Application No: BE/77/21/HH
Site Address: 19 South Way Bersted PO21 5HB
Description of works: Removal of 3 No existing lean-to structures & erection of single storey side & rear extensions, loft conversion to form new second floor with roof alterations to form gable end with rear dormer projection & detached outbuilding to be used as an annexe to the existing dwelling (resubmission following BE/37/21/HH).

Thank you for your internet representation made on 8th June 2021 which has been recorded as an objection with the comments as follows:

Ground floor plan
1 : 50

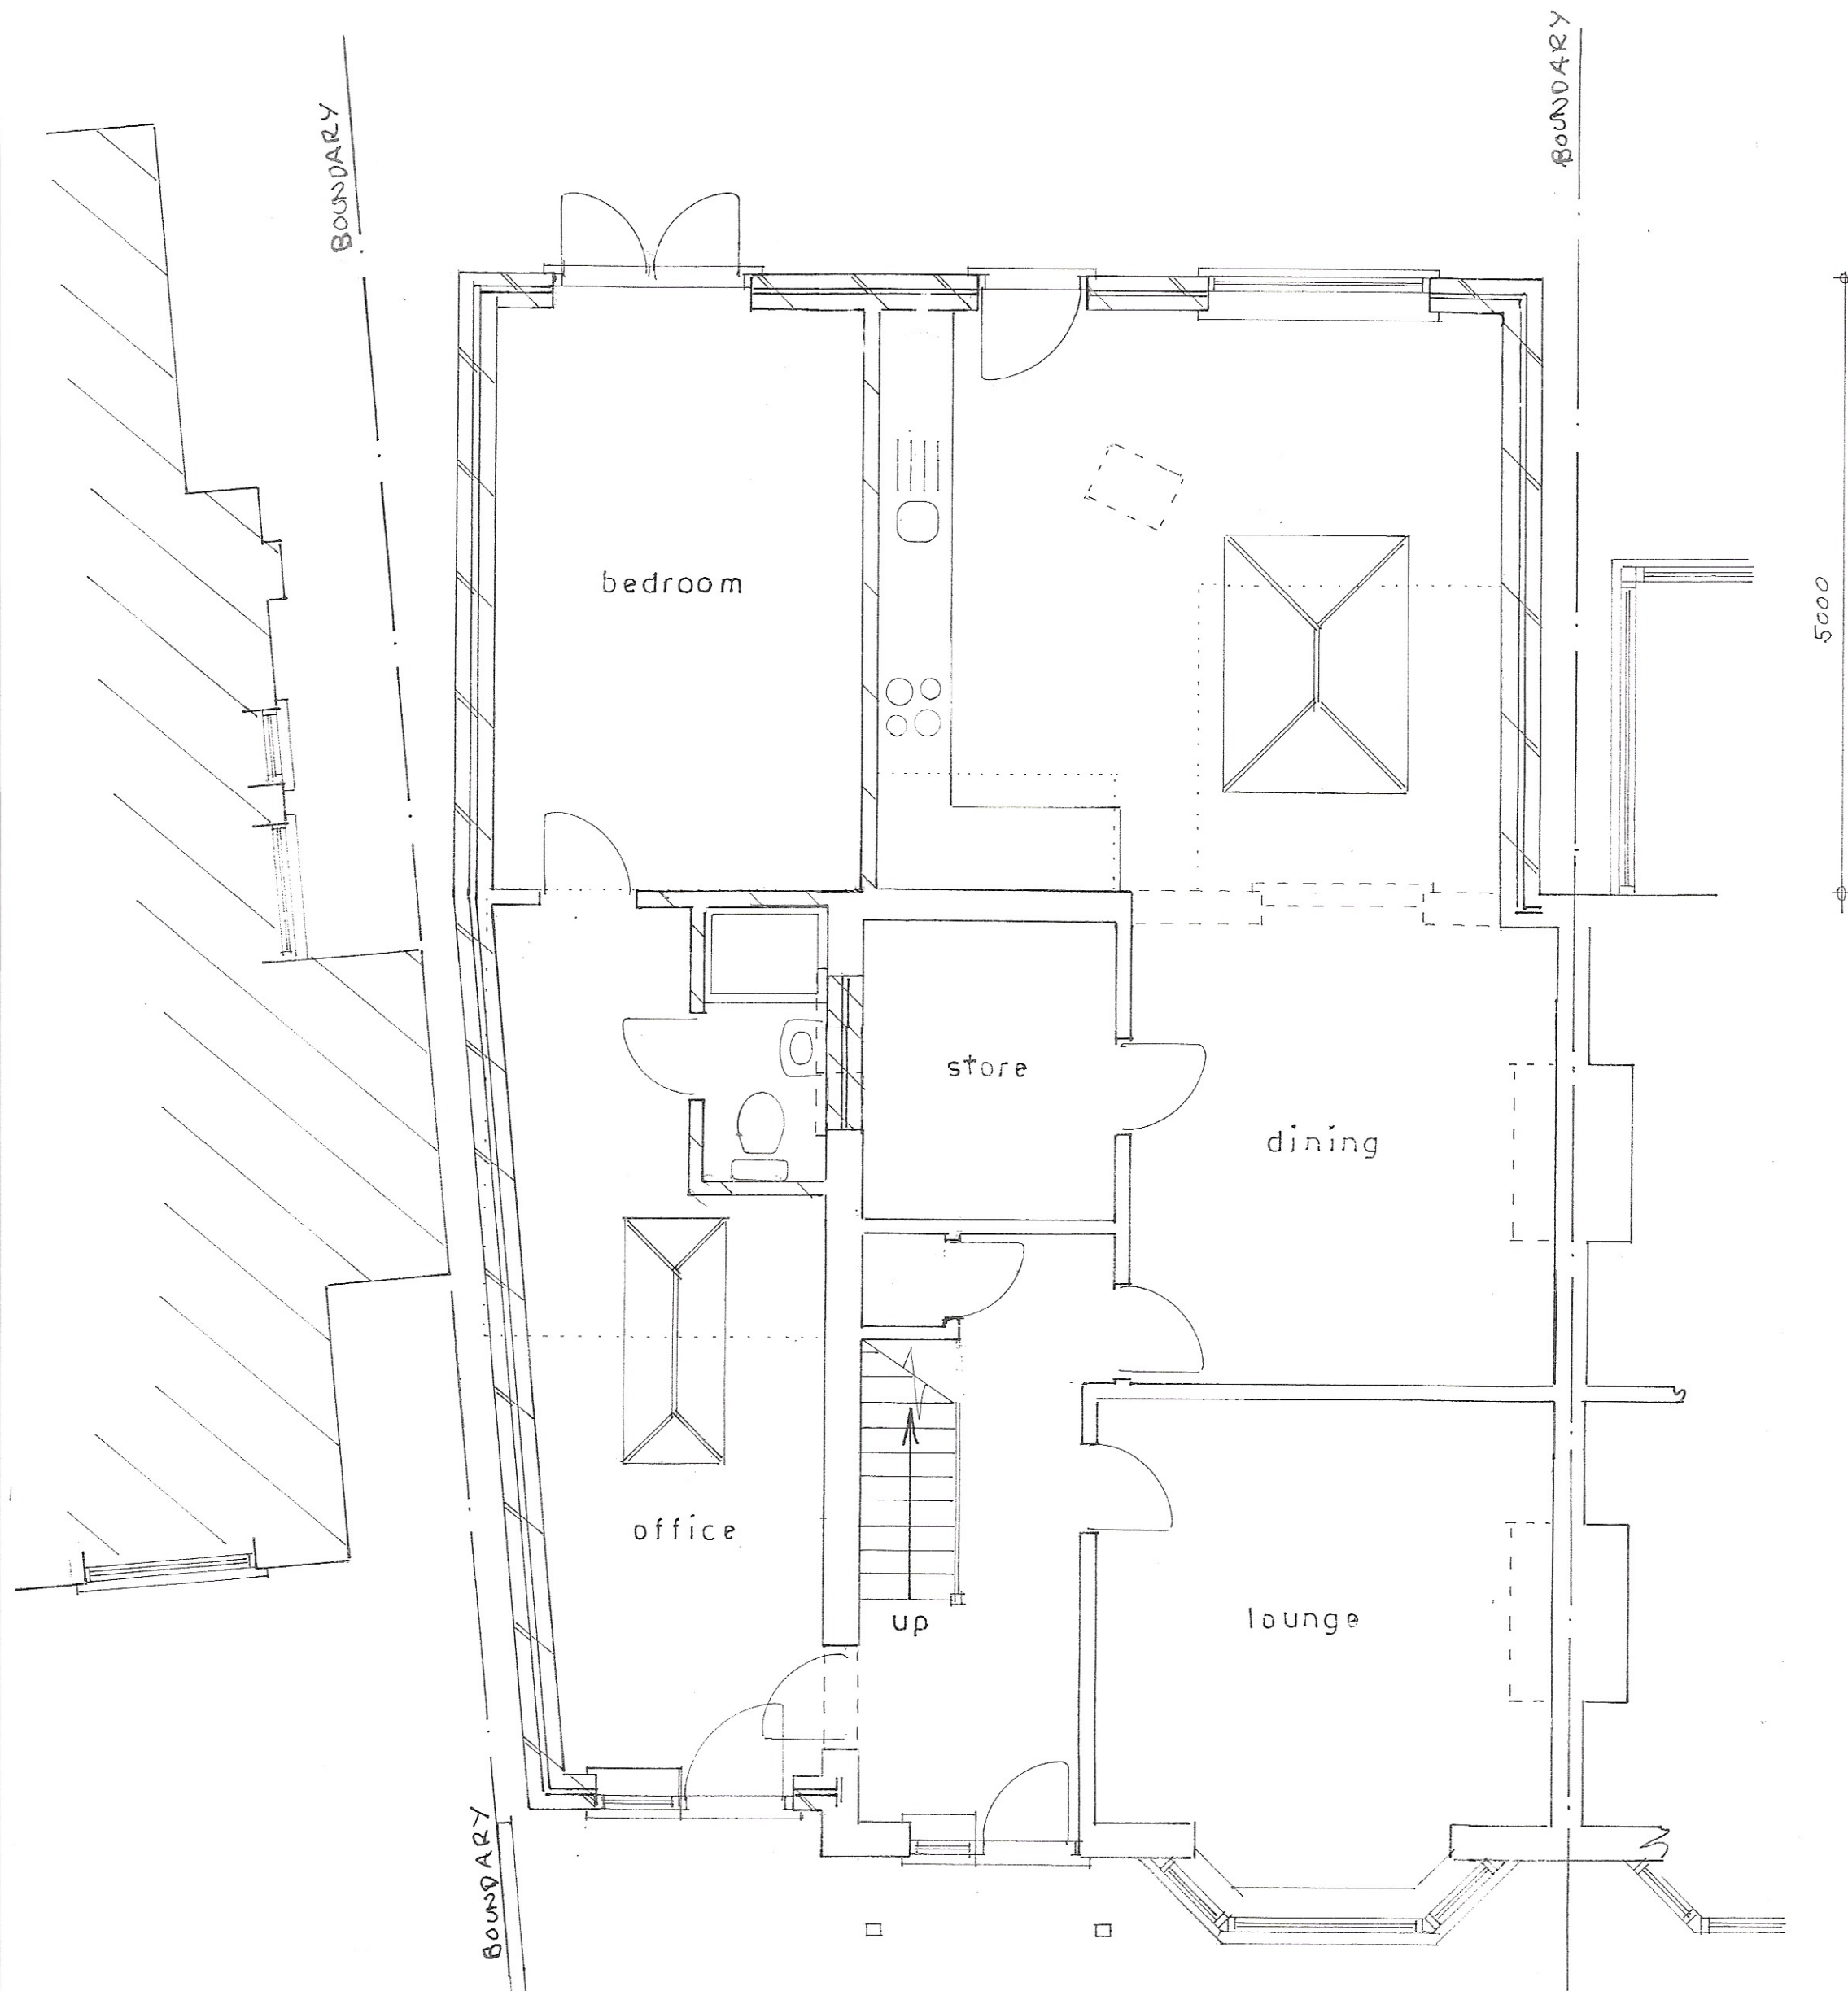
I feel the single storey extension is too big and too close to the property line and will block out light from our kitchen and dining room window. I also feel that adding an additional 4 bedrooms is excessive and seems more like a change of use from a family home to a house of multiple occupancy. There is no parking available and South way already has a lot of cars parking in the road. I also have concerns about an increase in noise from having a potentially large number of occupants and how the drainage/sewerage works will be affected adversely.
